RECOMMENDATION FOR PLANNING AND DEVELOPMENT COMMITTEE

APPLICATION REF: 3/2026/0375

PROPOSED SYNTHETIC TURF PITCH, INCLUDING FENCING, ACOUSTIC BARRIER, FLOODLIGHTING, ACCESS PATH, TOILET BLOCK AND ANCILLARY EQUIPMENT AT PLAYING FIELD, EDISFORD ROAD, CLITHEROE, BB7 3LA

Surface Water Strategy

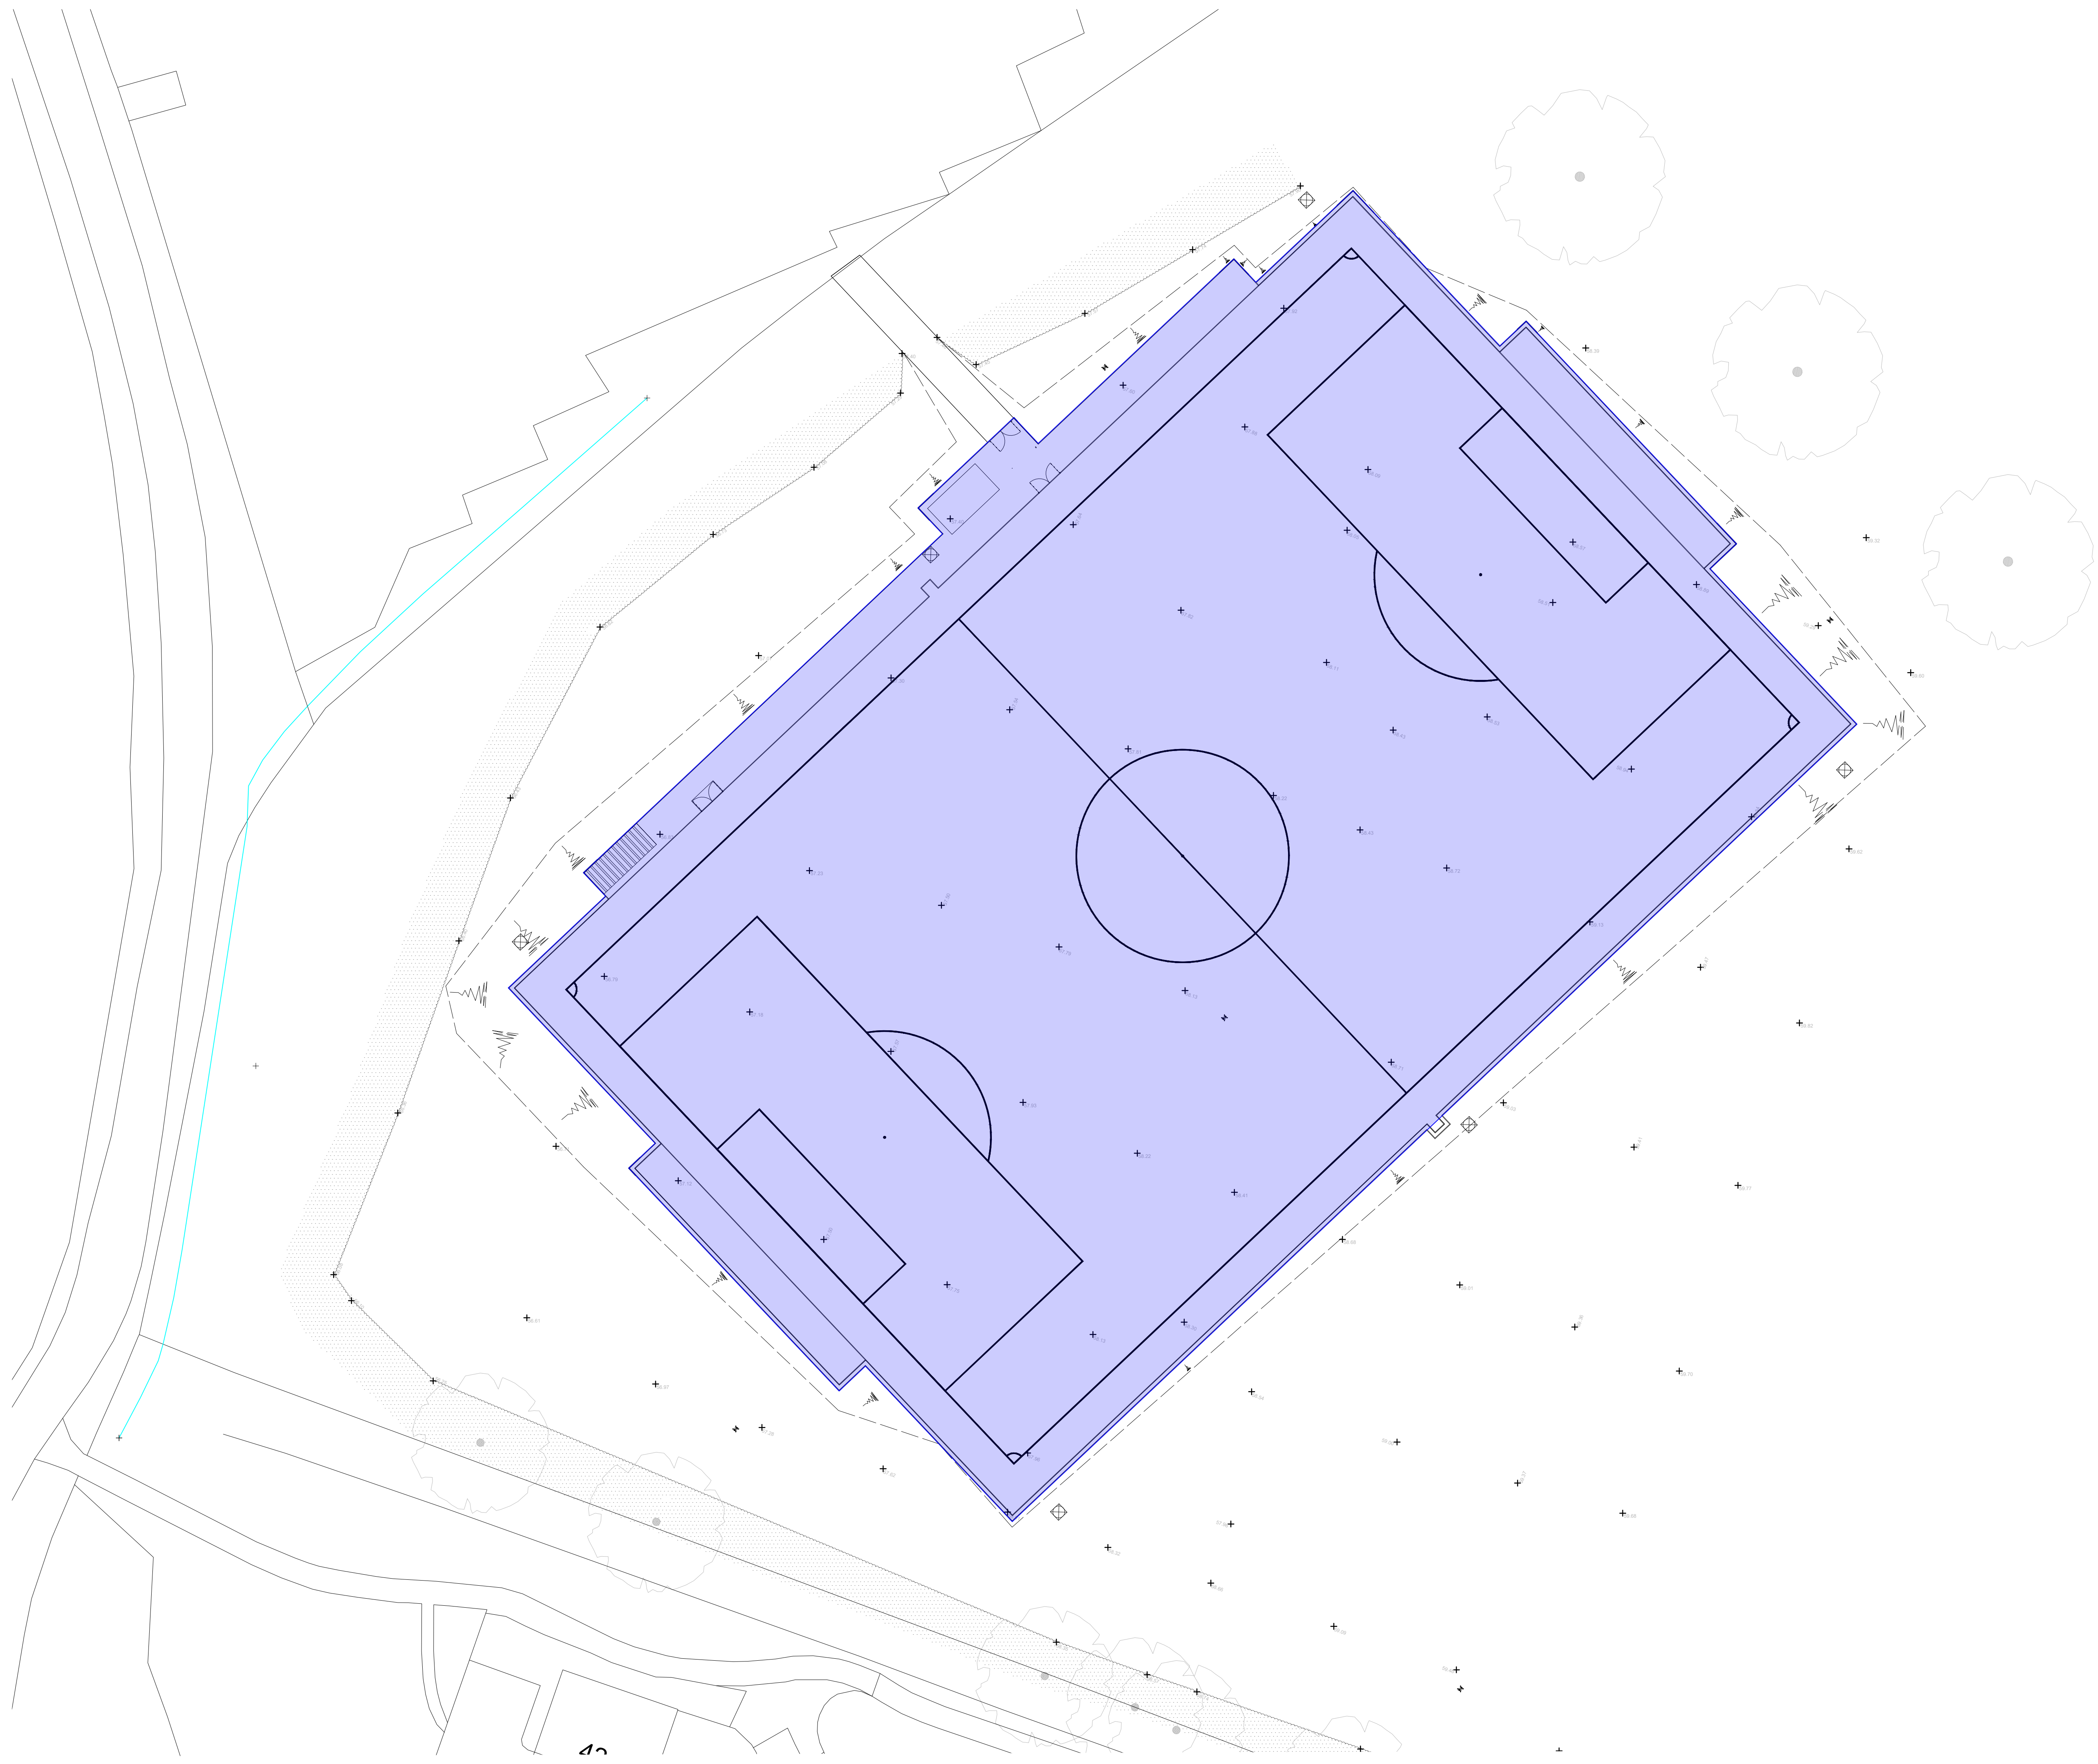
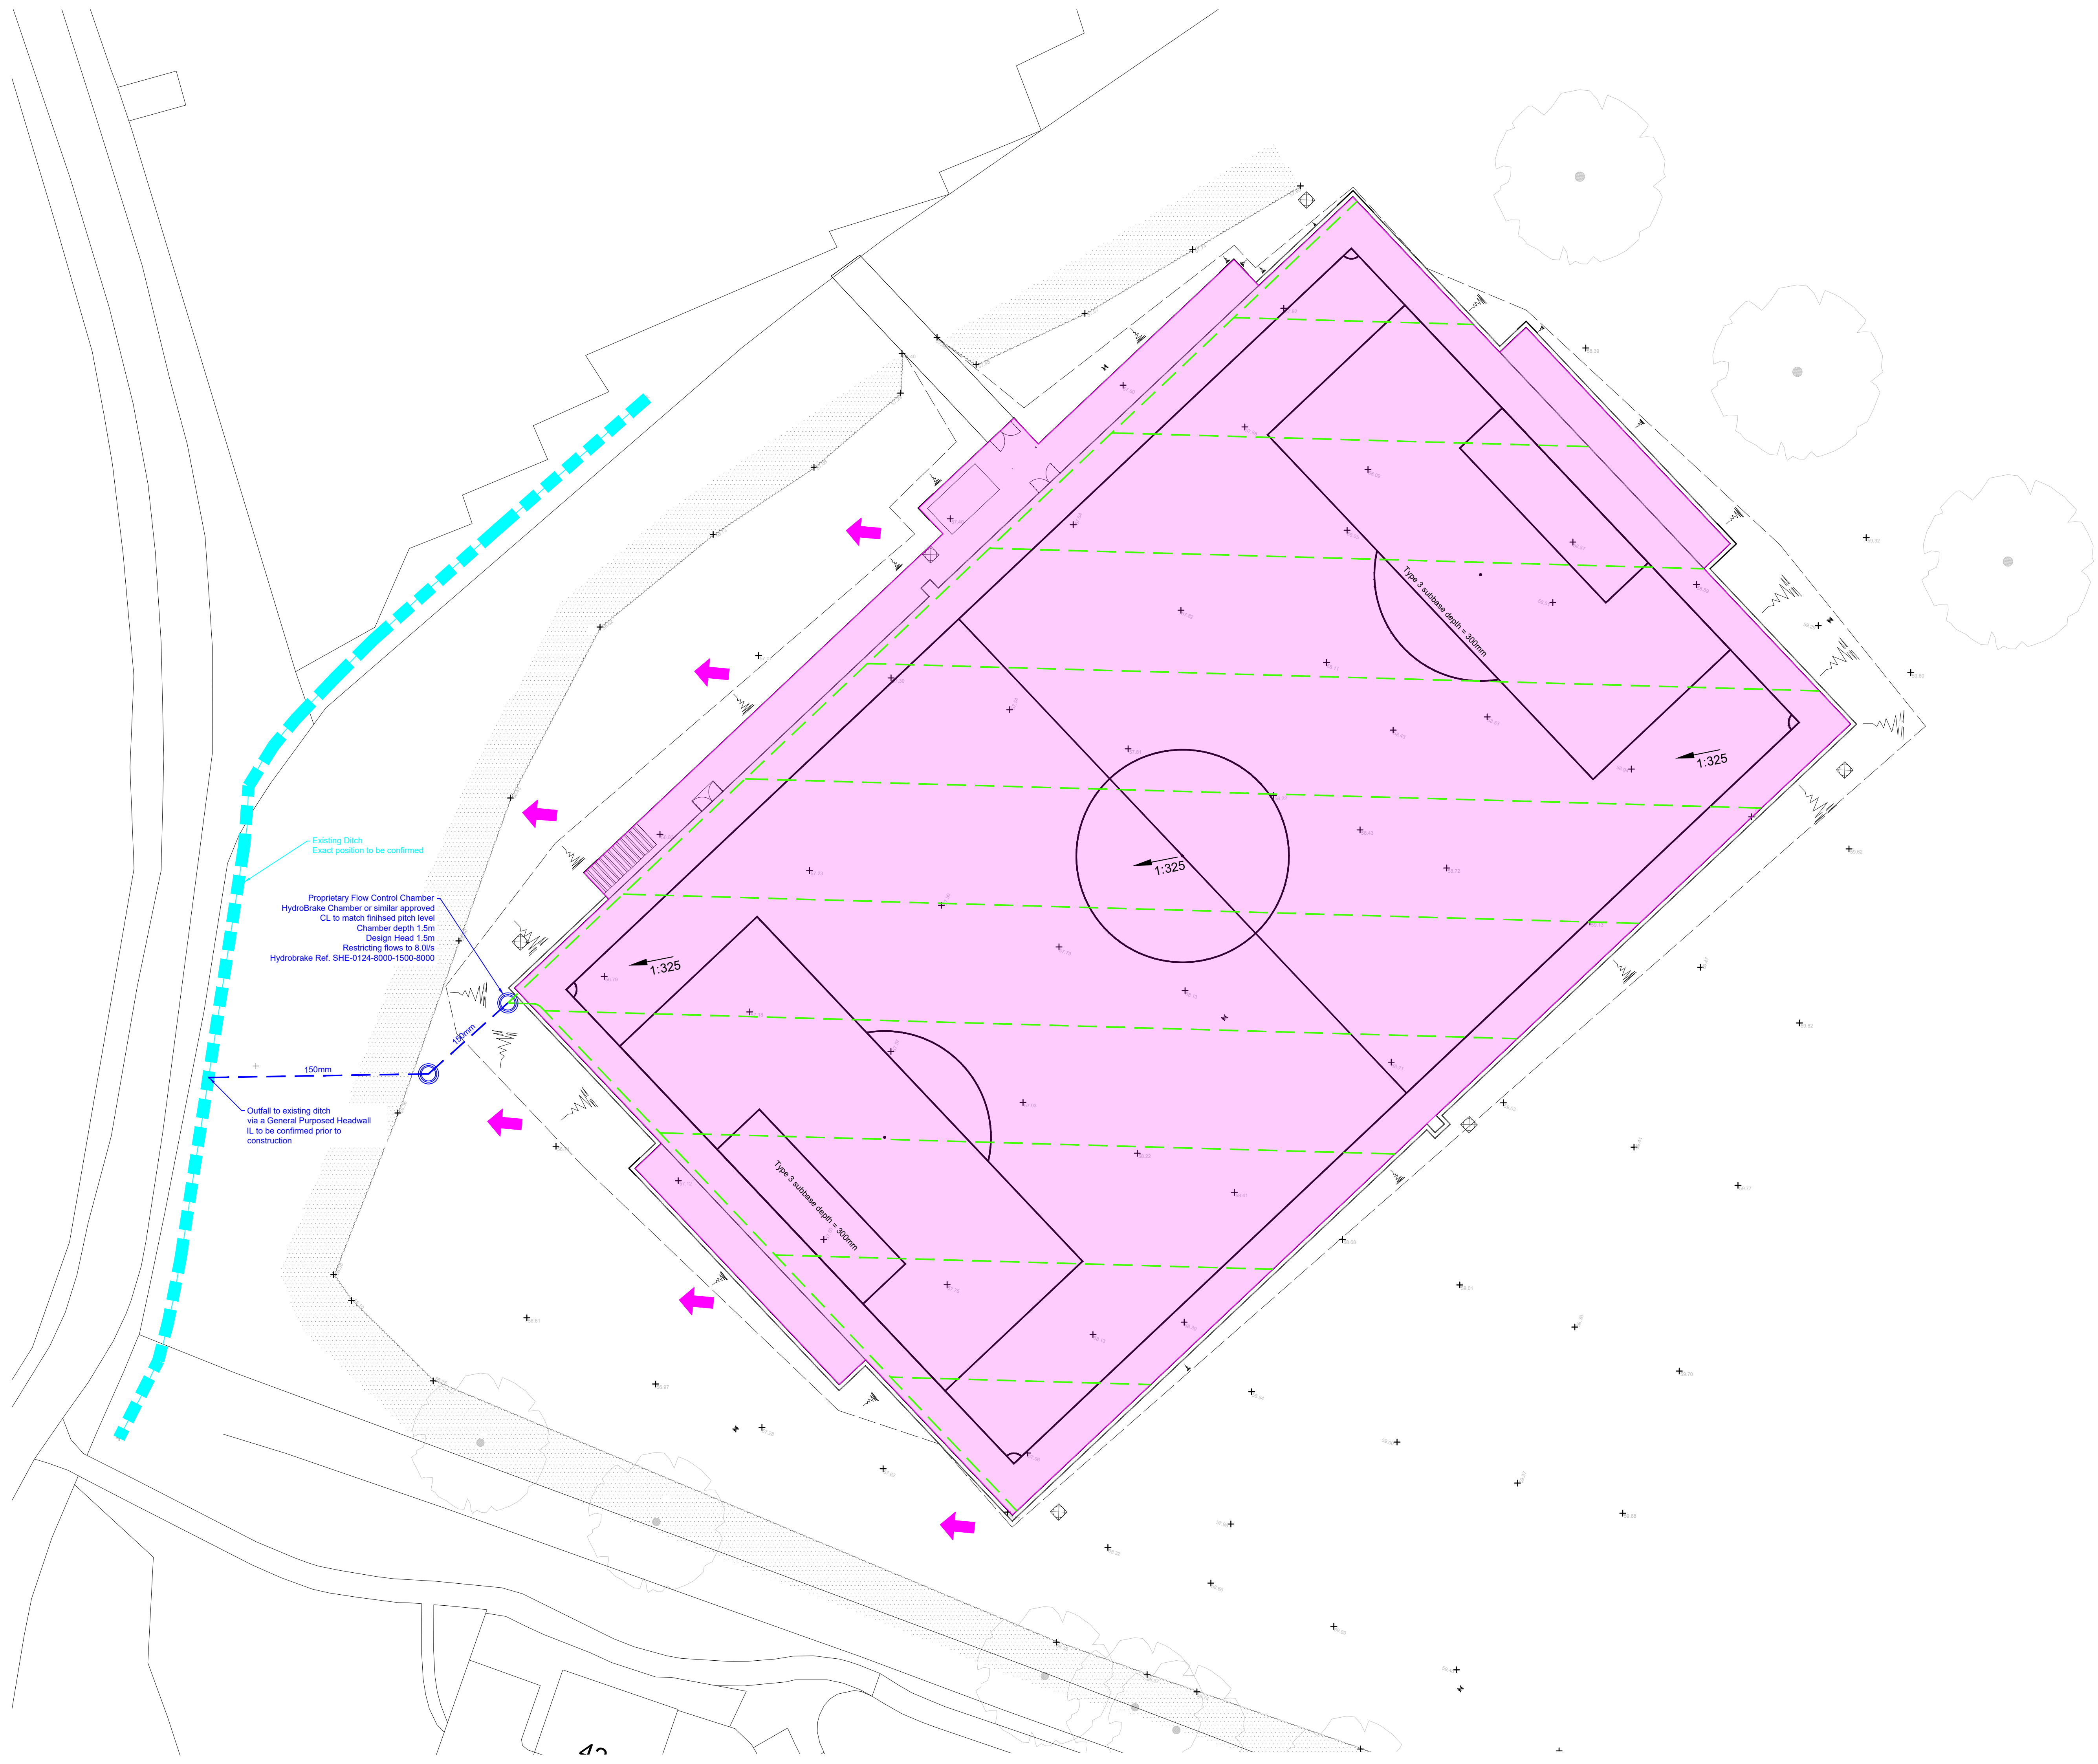
Sport England is satisfied that there is a strategic need for a sports lit 3G AGP, therefore there is a need to ensure that the AGP is kept to appropriate playing standards and they recommend a condition to secure this. They raise concern that the drainage system does not show any interceptors to prevent the 3G infill migrating into the environment and would need to be addressed by way of planning condition.

5.1.4 Sport England is satisfied that there is a strategic need for a sports lit 3G AGP, therefore there is a need to ensure that the AGP is kept to an appropriate playing standards and they recommend a condition to secure this. They raise concern that the drainage system does not showing any interceptors to prevent the 3G infill migrating into the environment and would need to be addressed by way of planning condition.
